PR-2024-010269

DHOWVR-2025-00015 – DHO WAIVER

DRB Project Number: PR-2024-010269 Hearing Date: 05-21-2025
Project: 3A1/CORONADO CENTER,
JEANNEDALE UNIT 6, located at
6600 MENAUL BLVD NE Agenda Item No: 1

SUBJECT: Sidewalk Waiver

CORONADO CENTER  
6600 MENAU BOULEVARD NE  
ALBUQUERQUE, NEW MEXICO 87110

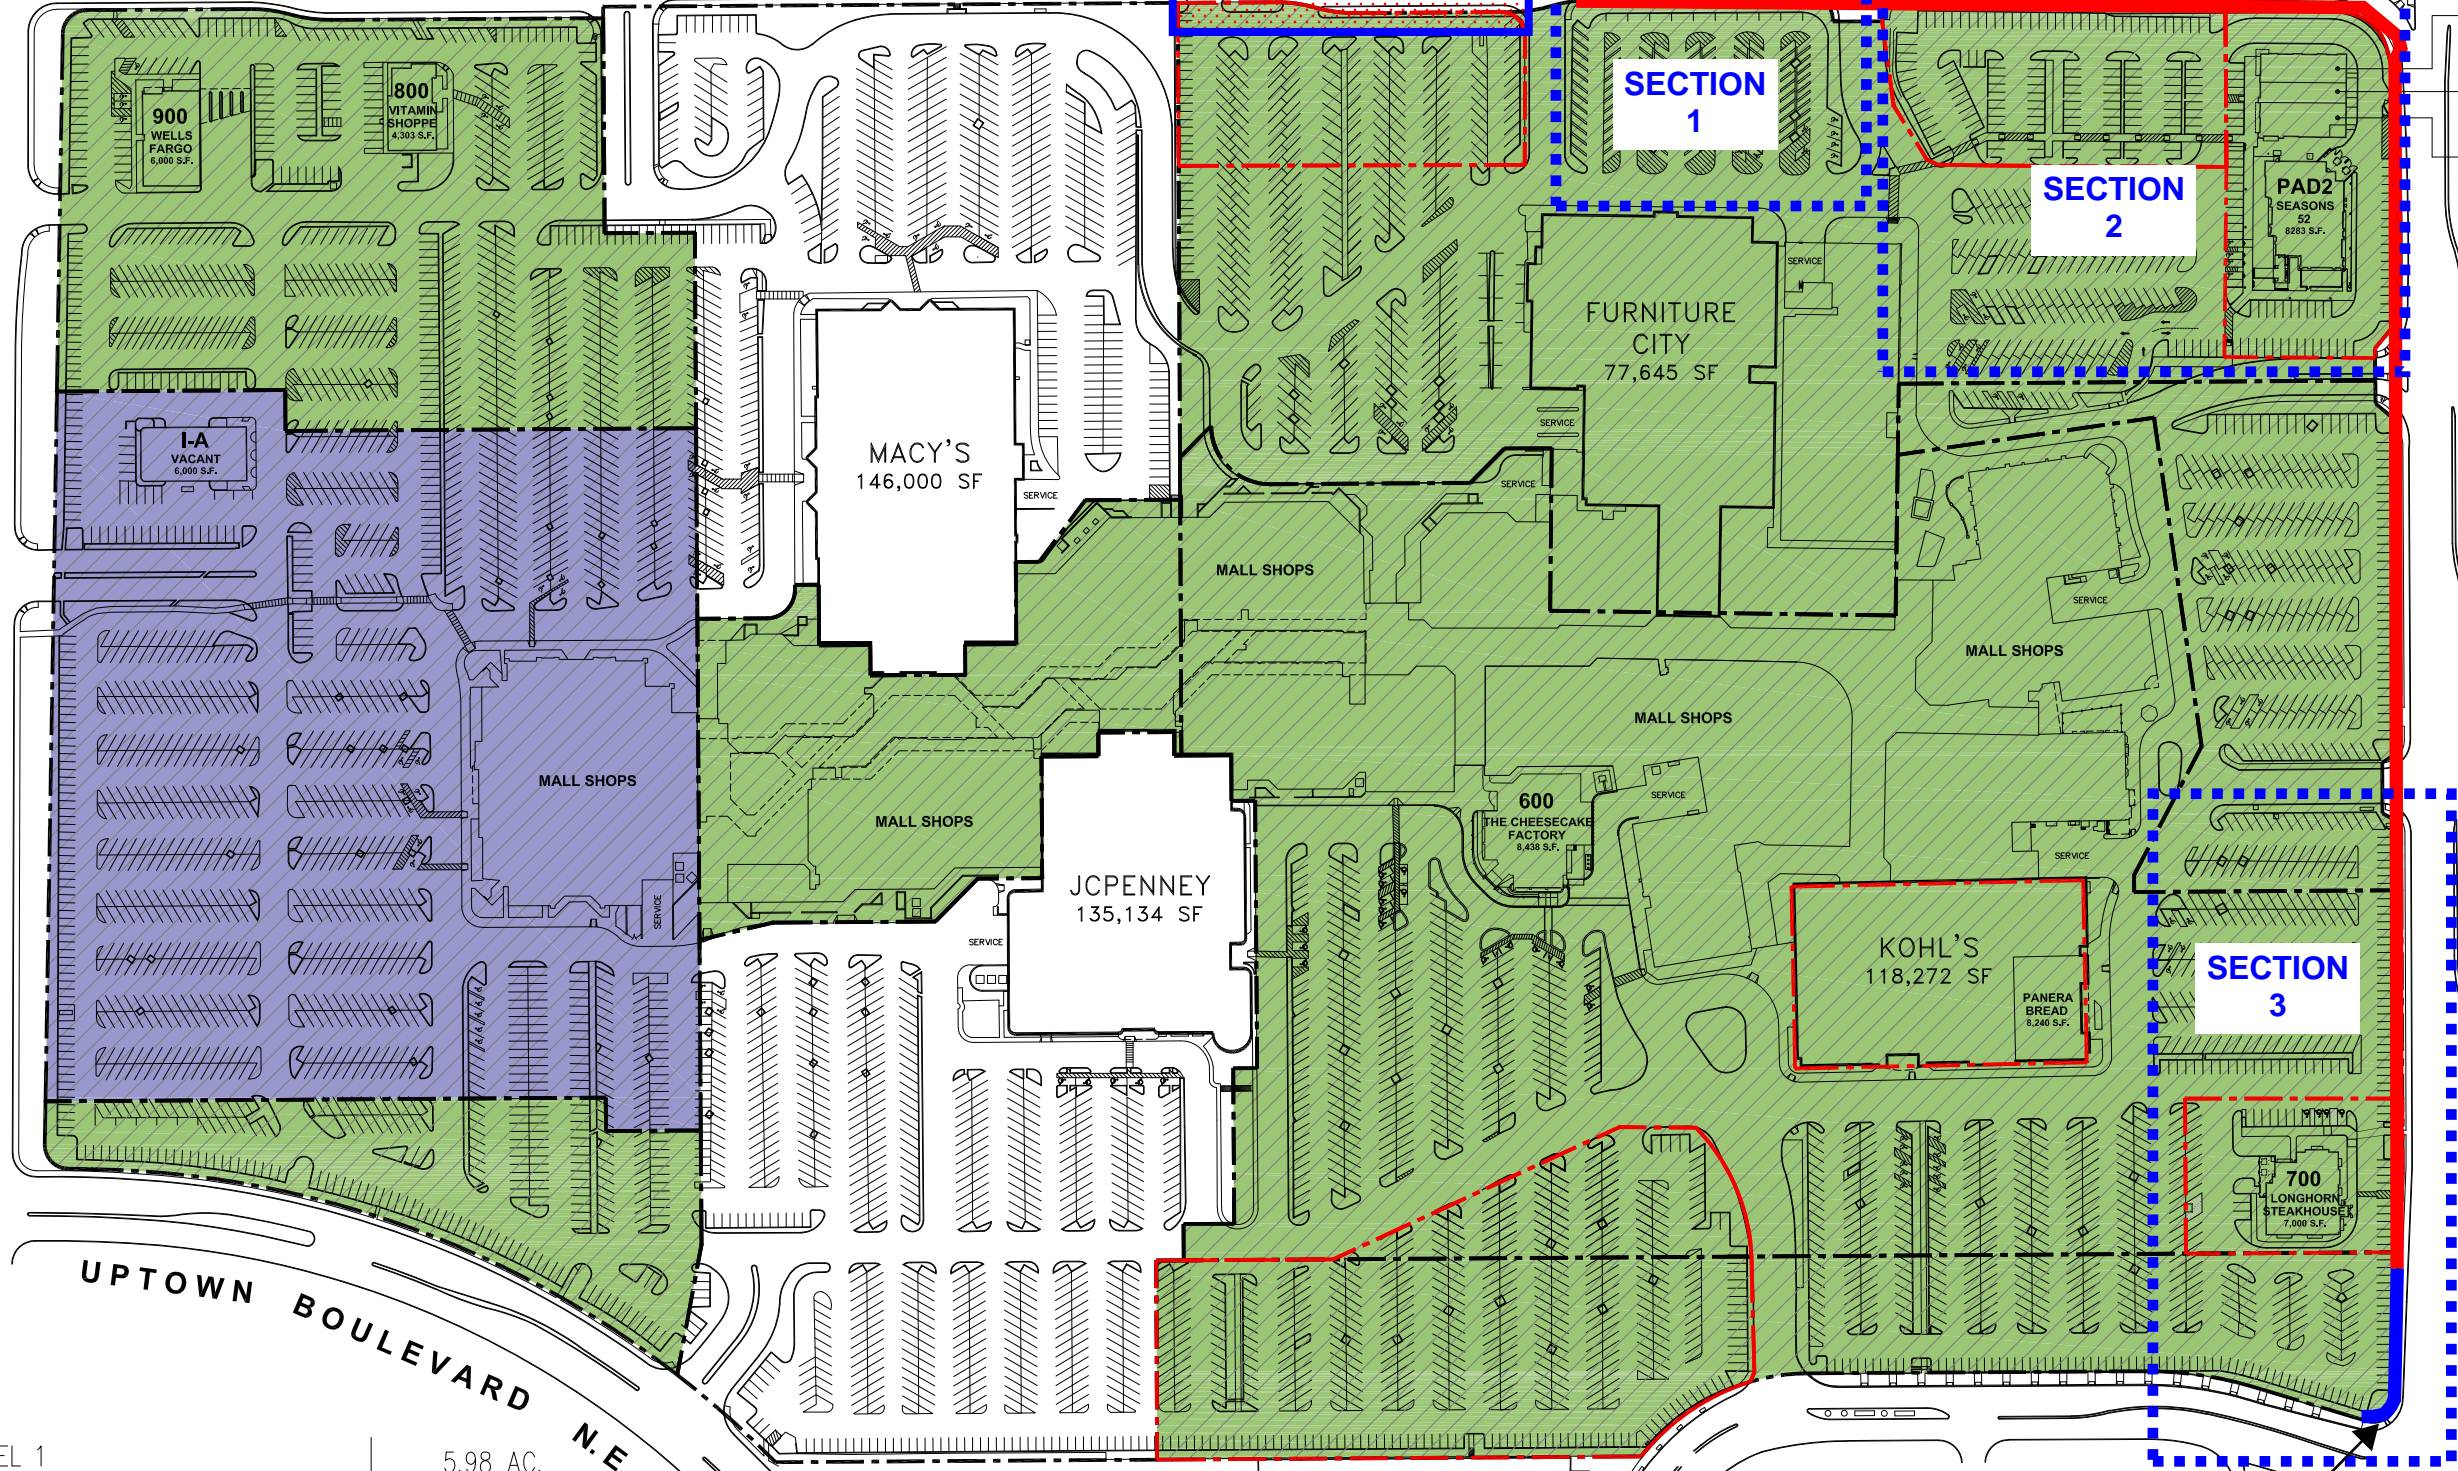
1. Transportation met with the applicant and the waiver was narrowed to areas where grades made widening the sidewalk not feasible. Sidewalk will be widened along a portion along Louisiana in the SE corner of the site. No objection.

- Planning defers to Transportation regarding the Sidewalk Waiver request and its compliance with 6-6(P)(3) of the IDO; in their memo, **Transportation notes in their memo that that the applicant met with Transportation staff, and the Waiver was narrowed to areas where grades made widening the sidewalk not feasible, and sidewalk will be widened where it is feasible, and has no objection to the request.**
